**Allambi Care – New Educational Establishment, West Wallsend (SSD-21822247)
Response to Submissions**

Attachment A – Key Issues

Allambi Care – New Educational Establishment, West Wallsend (SSD-21822247)

Landscape Plan

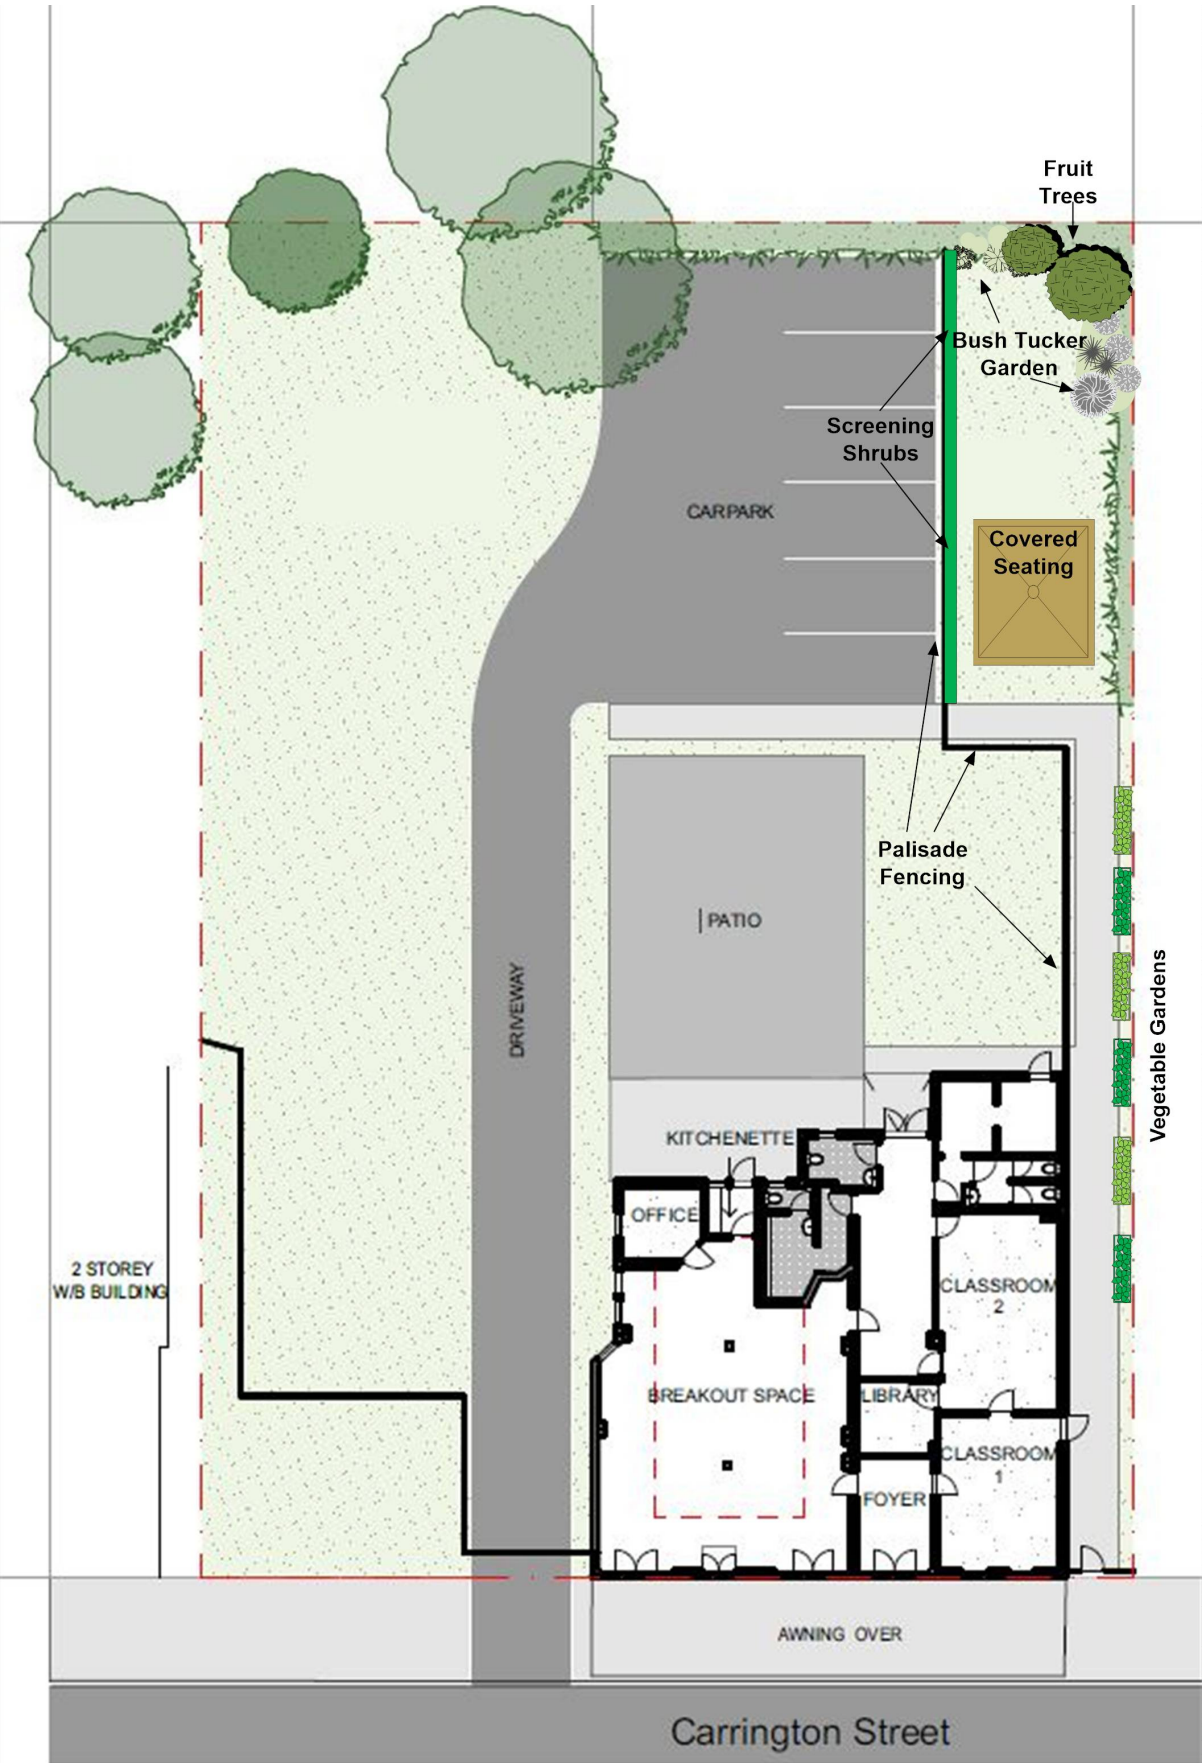
- It is requested that the Applicant consider opportunities to provide enhanced landscaping treatments on the site, particularly for the outdoor learning space. Landscape elements including new shrubs, garden beds and provision of outdoor furniture should be considered. This should be detailed on a landscape plan prepared for the site.
- Aerial imagery of the site shows a hills hoist currently located in the future outdoor learning space. It is requested that the structure be removed or relocated given its location in the outdoor learning and recreation space.

Ground Floor Plan

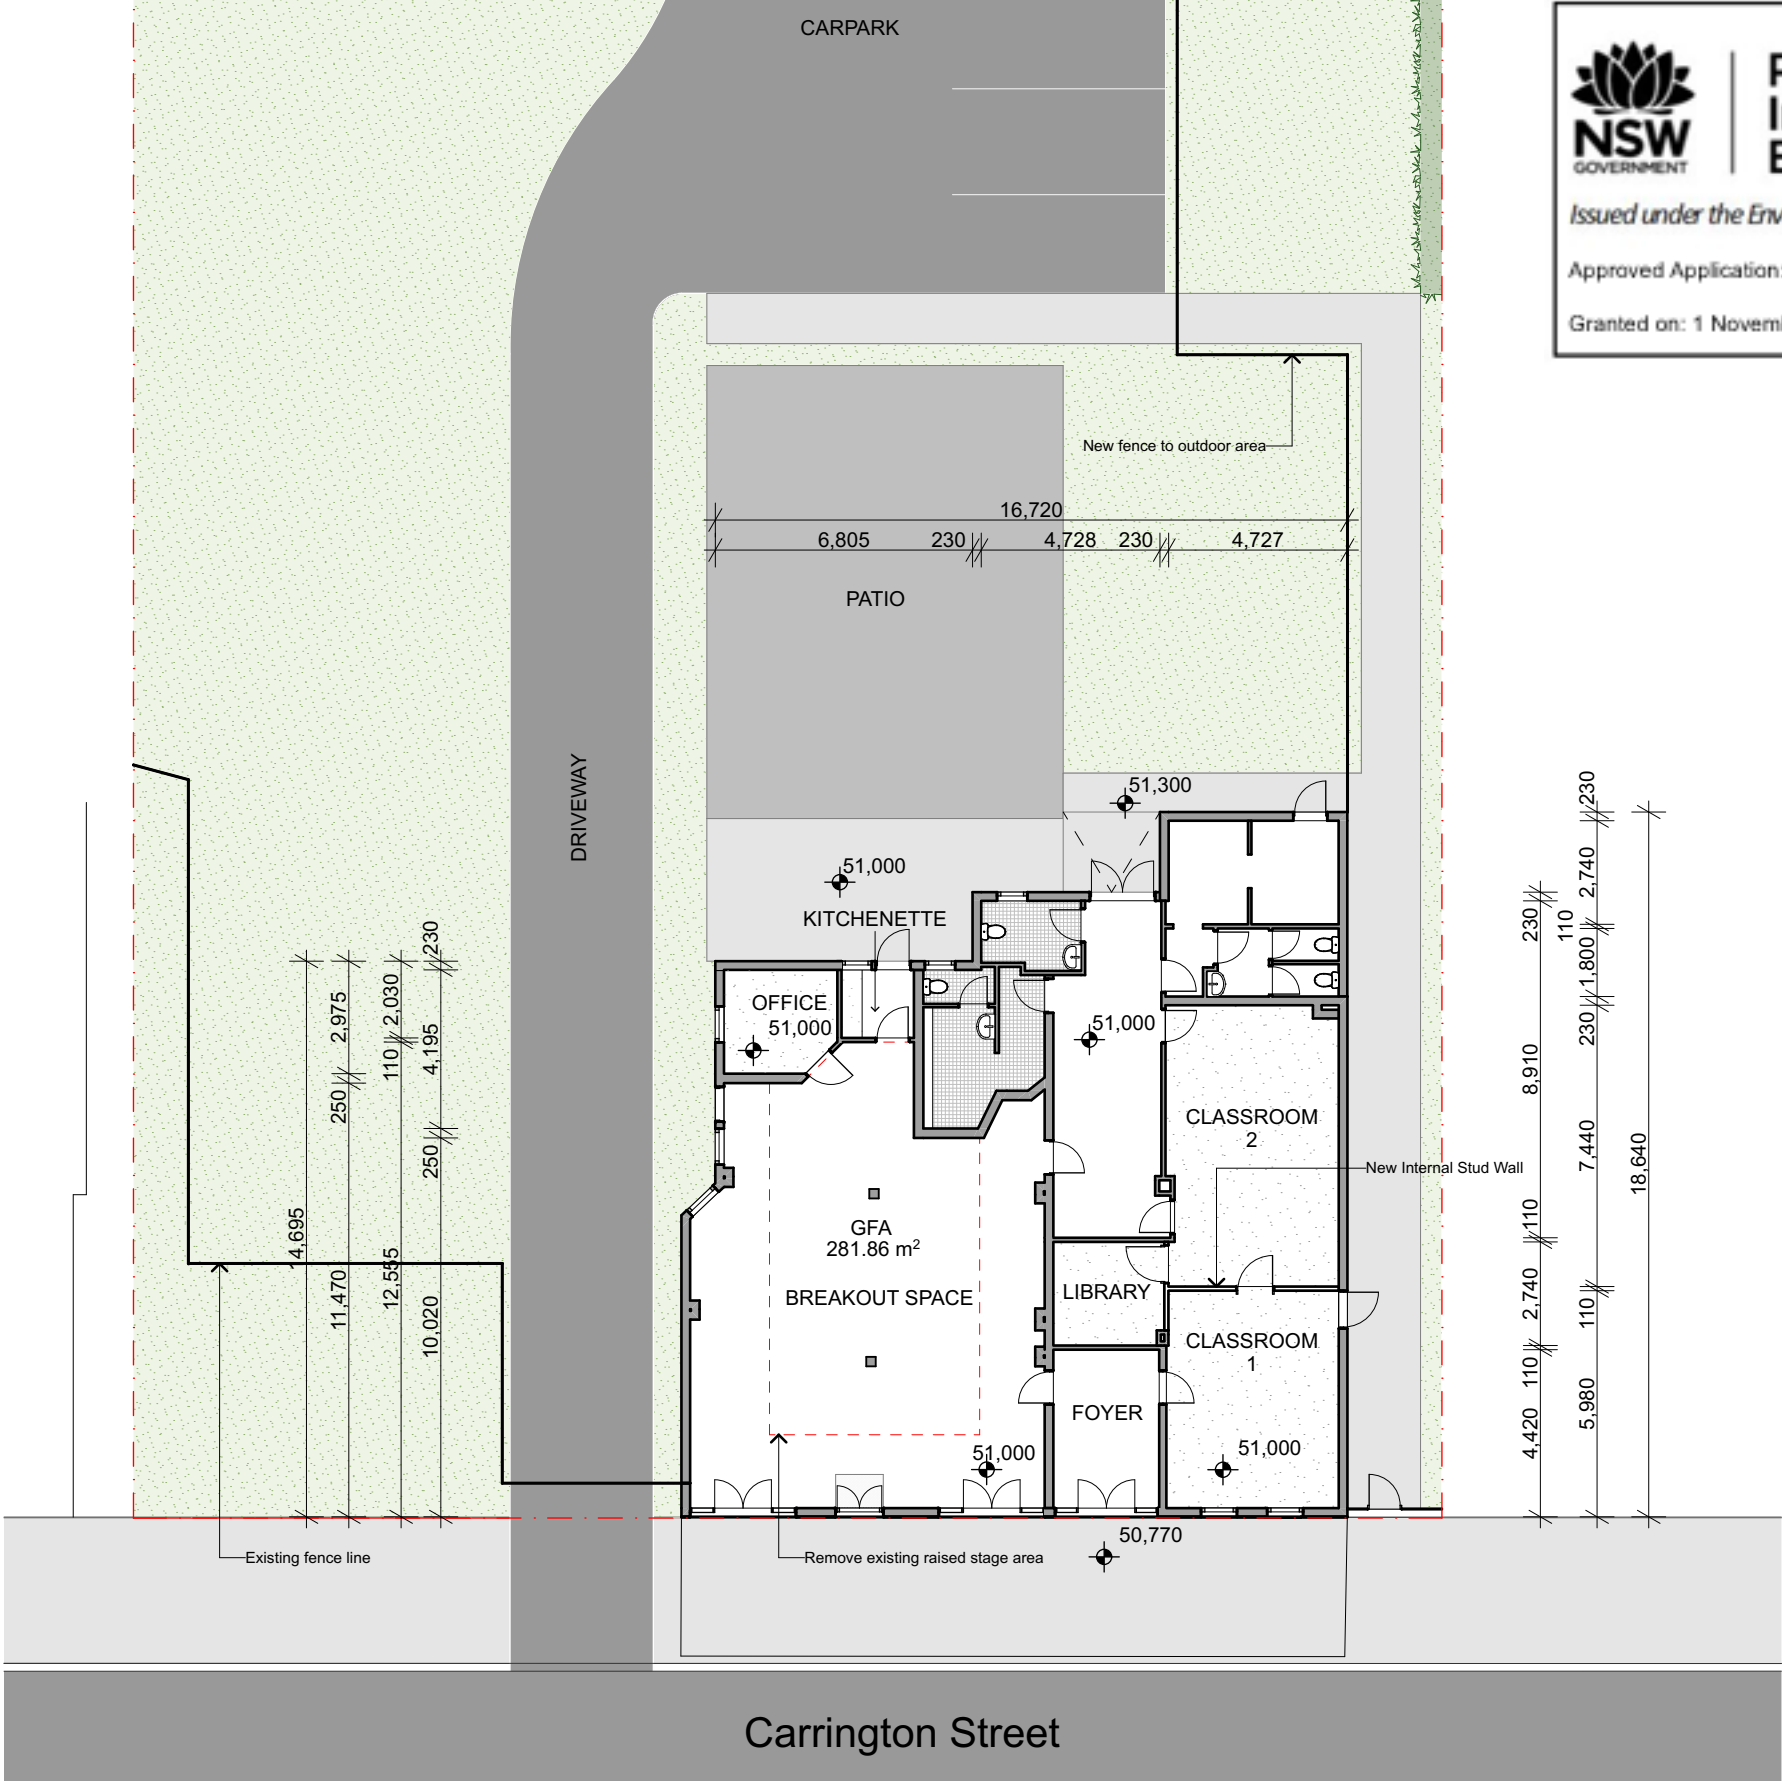
- The Response to Submissions (RtS) should include a list of all internal alterations and additions required to facilitate the building's ground floor change of use from a commercial premises to a school (i.e. alterations to the former servery in the main bar area, the raised stage area and any other existing elements).

- The architectural drawings show the location of a new fence to the outdoor learning space. The RtS should provide further details on the proposed fencing including the material(s) that would be used for its construction, indicative height and location of openings or gates. The new fence should be detailed on the landscape plan requested above.
- The proposed fence along the eastern extent of the site would isolate a small parcel of land adjacent to the on-site car park (Lot 12 (Section B) in DP 2252). Confirm whether this part of site would be utilised by the school as outdoor recreation or learning space.
